Consultation Response from KC, Highways Development Management
2025/91404 Holt Farm, 35, Holt Lane, Holmfirth, HD9 3BW
Prior notification for change of use of agricultural building to 2 dwellinghouses and associated building works or operations
Date Responded: 04/06/2025 Responding Officer: D. Stainsby Responding Ref: K3-37/41

Block Plan 1: 500

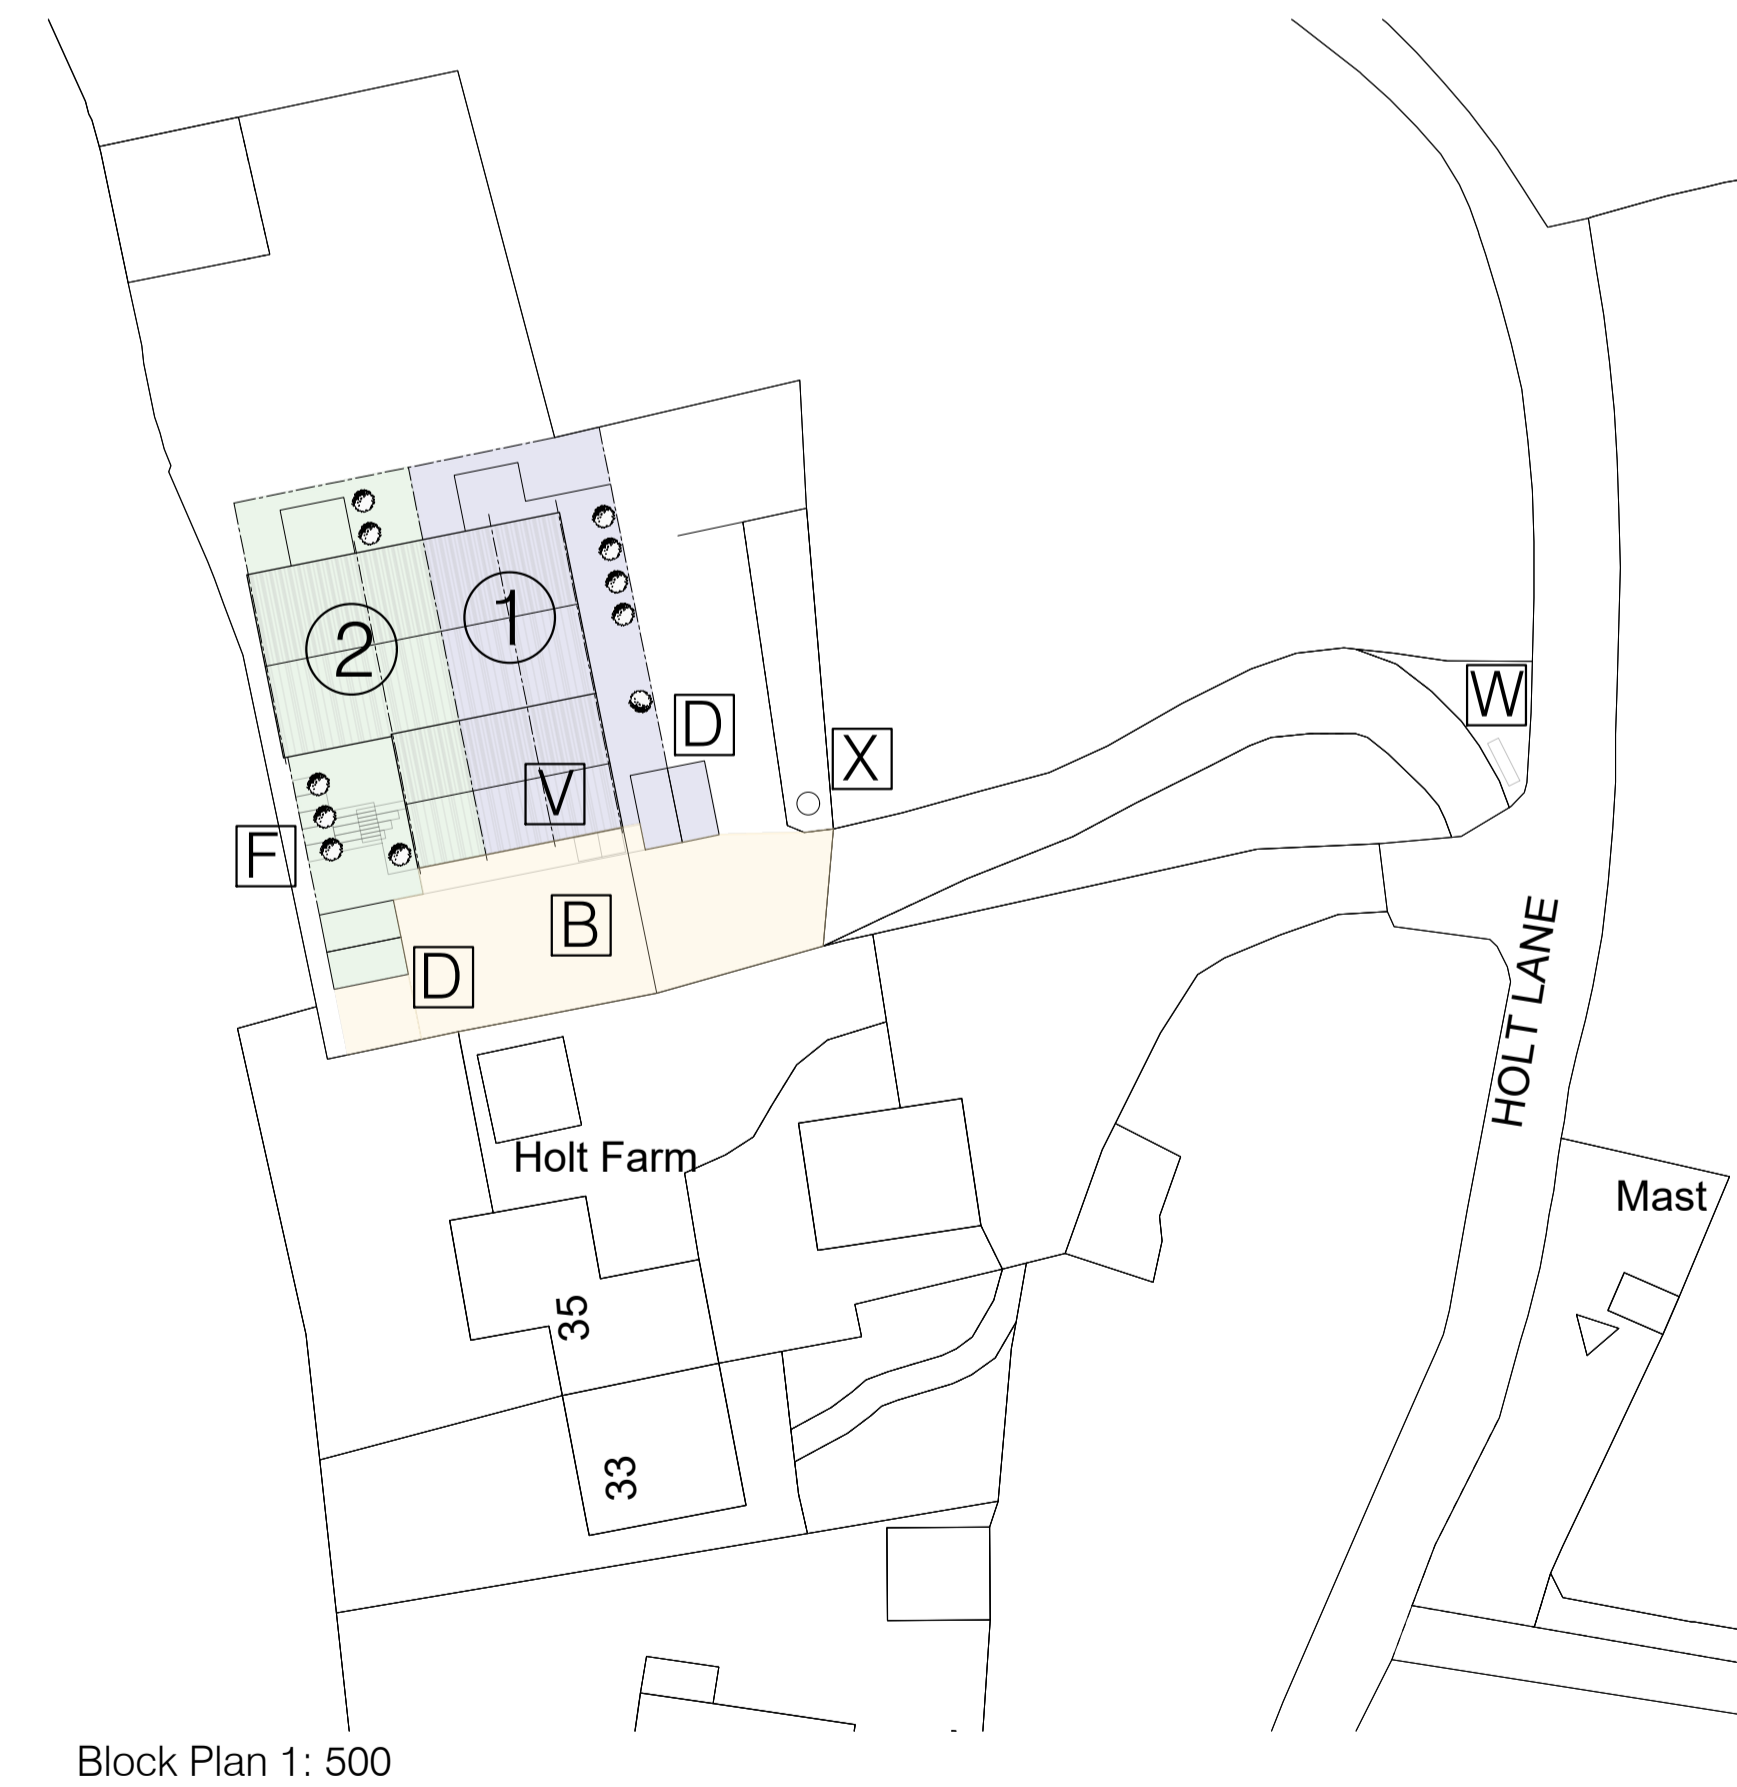
The Applicant has stated that the proposed dwellings would be accessed via an existing track from Holt Lane. However, the access appears to terminate within the existing site entrance to Holt Farm before reaching Holt Lane.

The red line boundary needs to be extended to the adopted highway to ensure access can be achieved.

Any gates should be set back a minimum of 5 metres from the adopted highway.

Four car parking spaces (2 per dwelling) together with internal turning are proposed which is acceptable.

A bin collection/presentation point is proposed adjacent to the entrance and is acceptable

In conclusion, subject to receiving an amended plan showing the red line boundary extending to the adopted highway access, parking and servicing arrangements are considered acceptable. It is considered that traffic associated with the development will have no material impact on the operation or safety of the highway network.
